Restart of the Redbank Power Station Project (SSD 56284960)

Independent Merit Review of the EIS

Reference: 305102-01

Final Report | 13 December 2024

Figure 19 – View of modified silo bases and Biomass fuel feeders

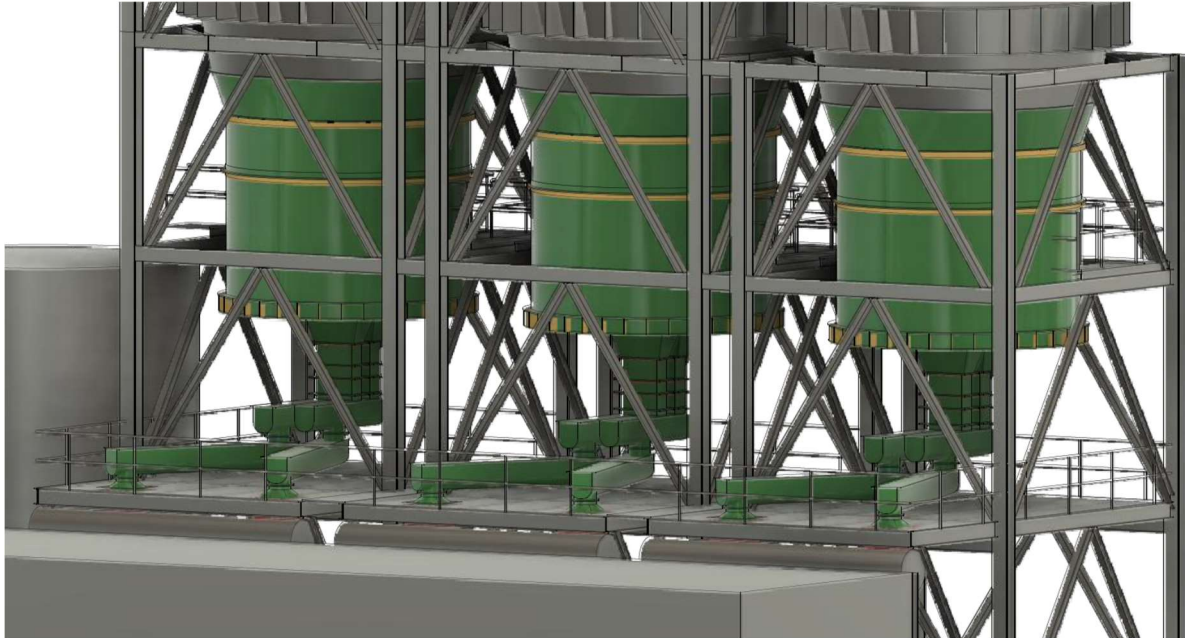
Proponent to confirm to what extent the biomass pulverisation has been modelled
